M54 to M6 Link Road

From: pramesh chandra [REDACTED]
Sent: 03 November 2020 18:30
To: M54 to M6 Link Road; Church, Eleanor; r.cope@sstaffs.gov.uk
Subject: Re: M54 to M6 Link Road - Live Streaming update
Attachments: TR010054-000534-TR010054 M54 2.7 P03 Streets, Rights of Way and Access Plans_EXTRACT.pdf; TR010054-000115-TR010054 M54 2.7 Streets, Rights of Way and Access Plans_EXTRACT.pdf

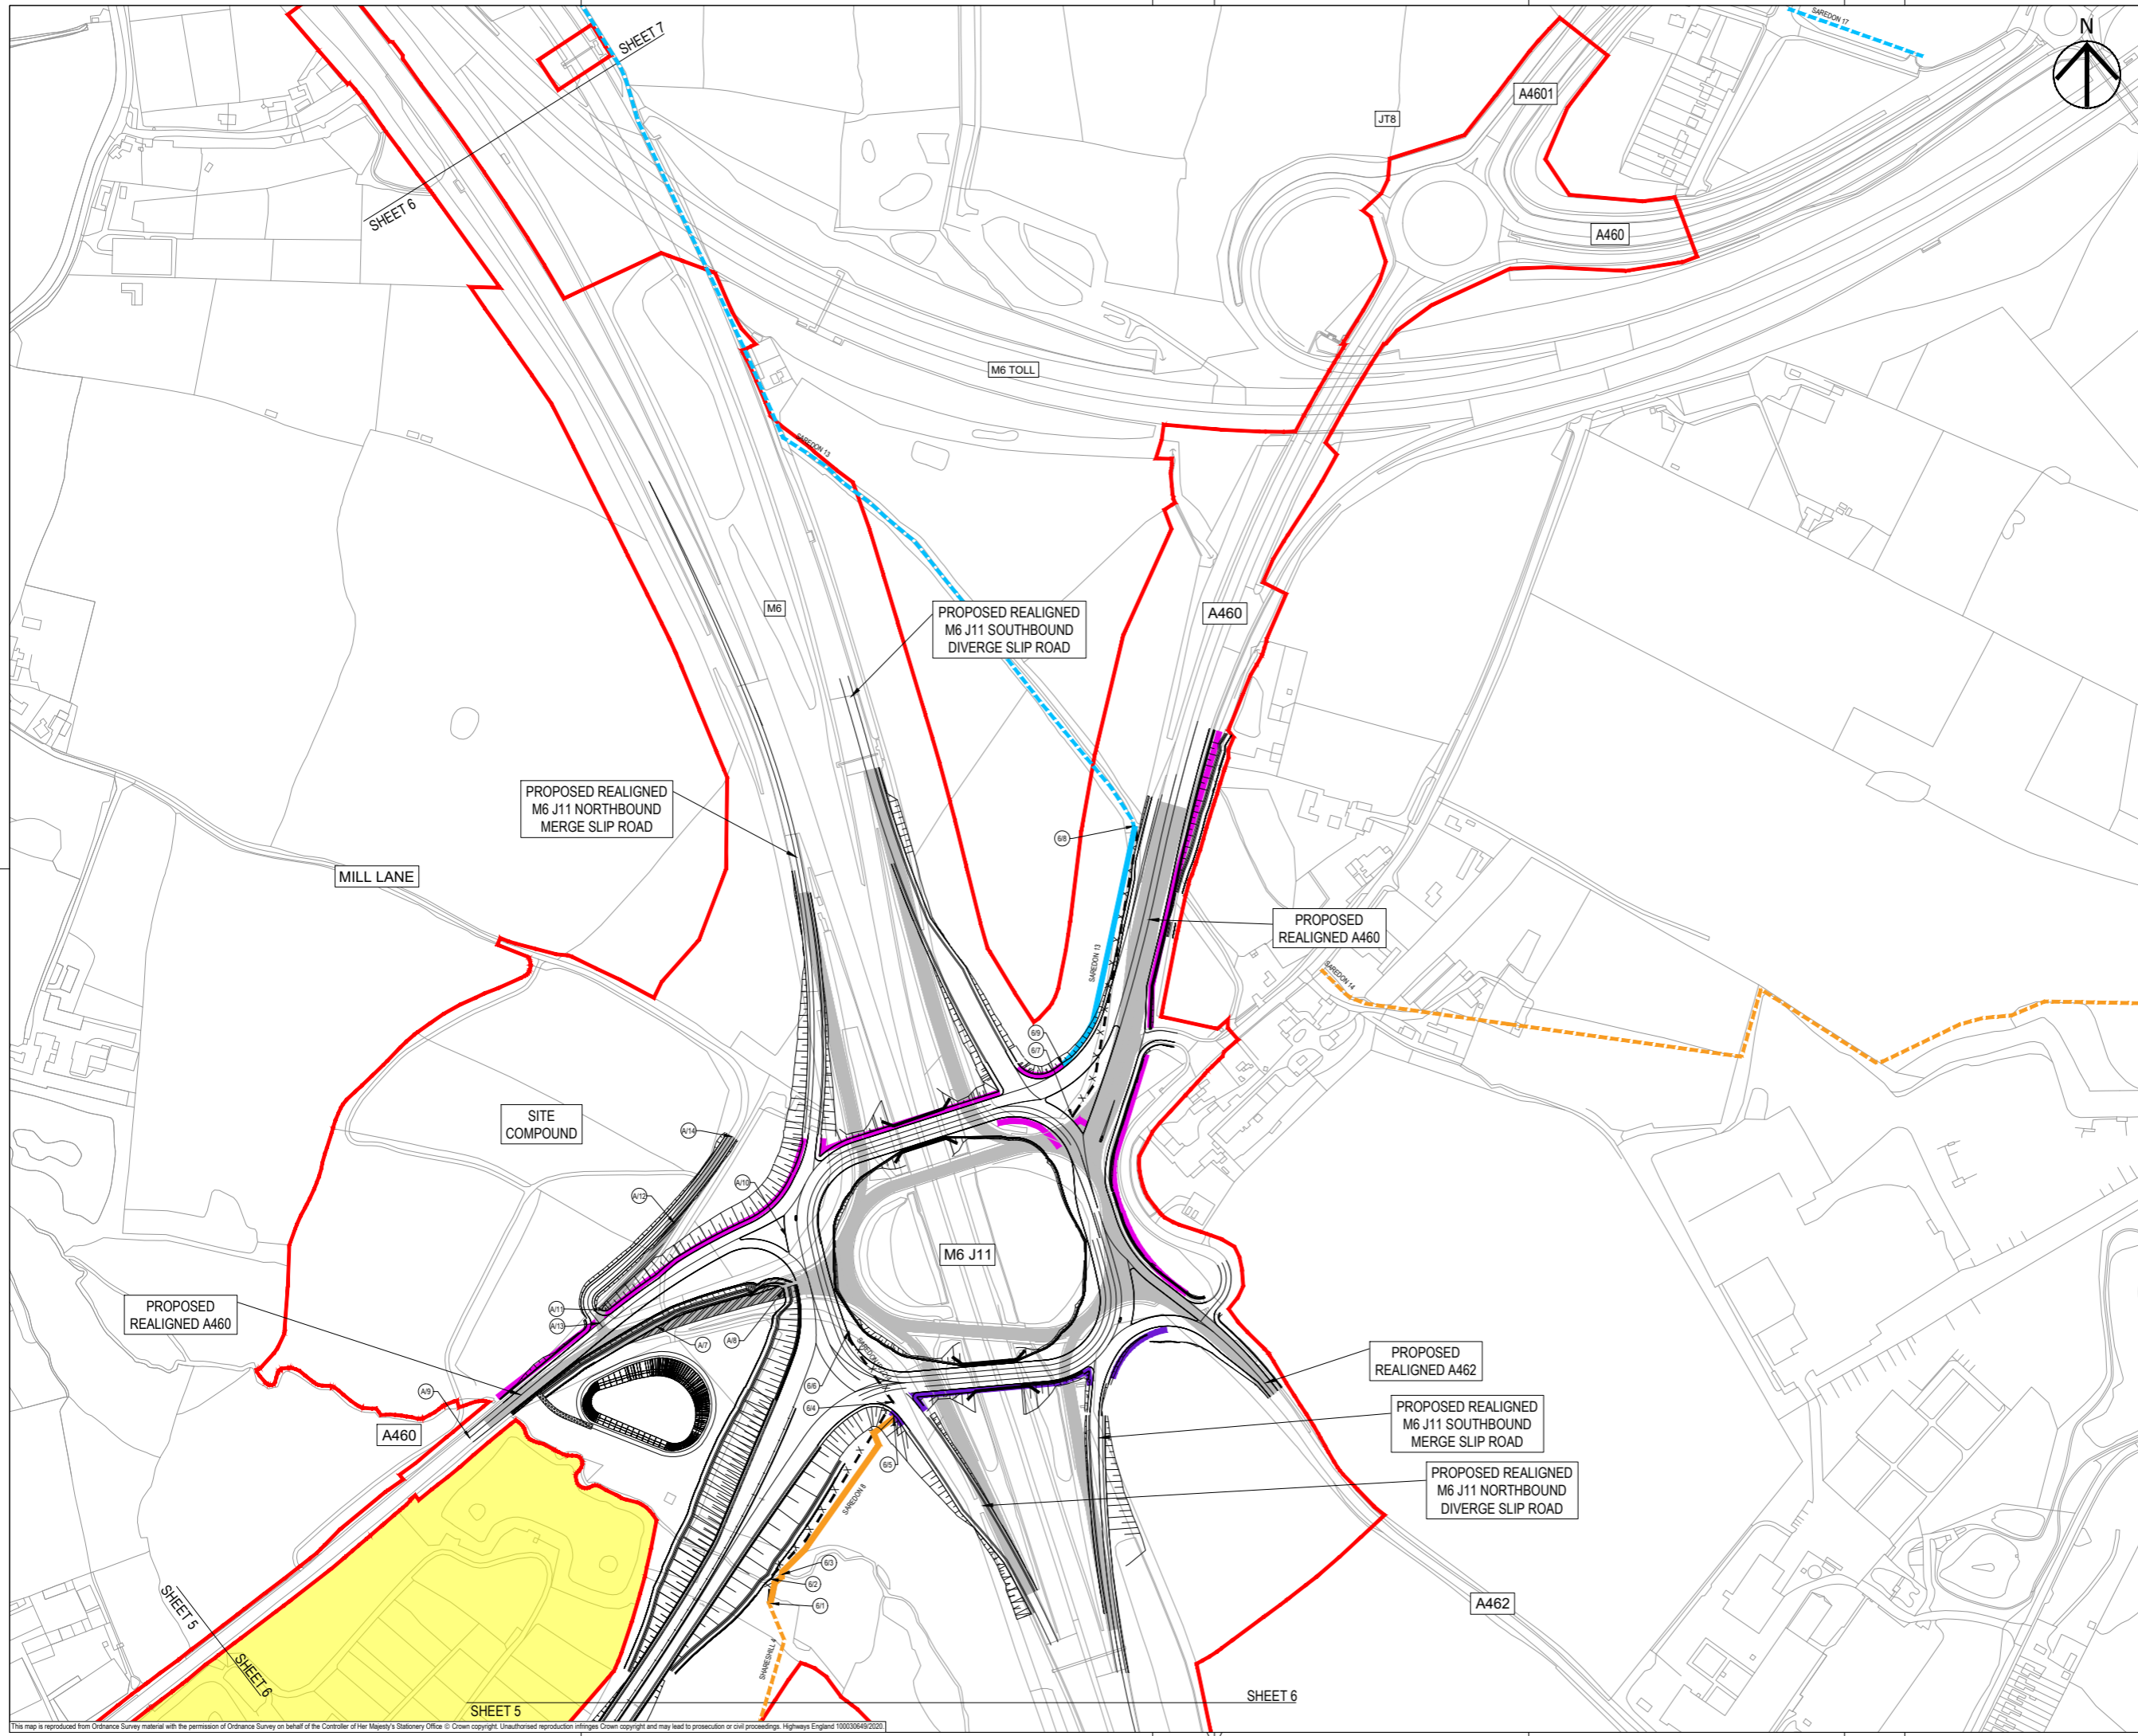
My query is related to the change in the PRoW on Hilton Lane. Currently this runs through the side of a residential property and a commercial business (Majestic Travels) and then continues onto the field. Original plan published Jan 2020 (see attachment bubble 5/2 on TR010054-000115-TR010054 M54 2.7 Streets, Rights of Way and Access Plans_EXTRACT) stated that this will be removed from the domestic and commercial business and a new footway was proposed; however, the latest plan has this modified and gone back to the current PRoW i.e. running through the domestic and commercial business (see attachment Published Oct 2020 TR010054-000534-TR010054 M54 2.7 P03 Streets, Rights of Way and Access Plans_EXTRACT) . I do not understand the reason for this change and strongly object as this is not often maintained and poses a safety risk where walkers have to tread on.
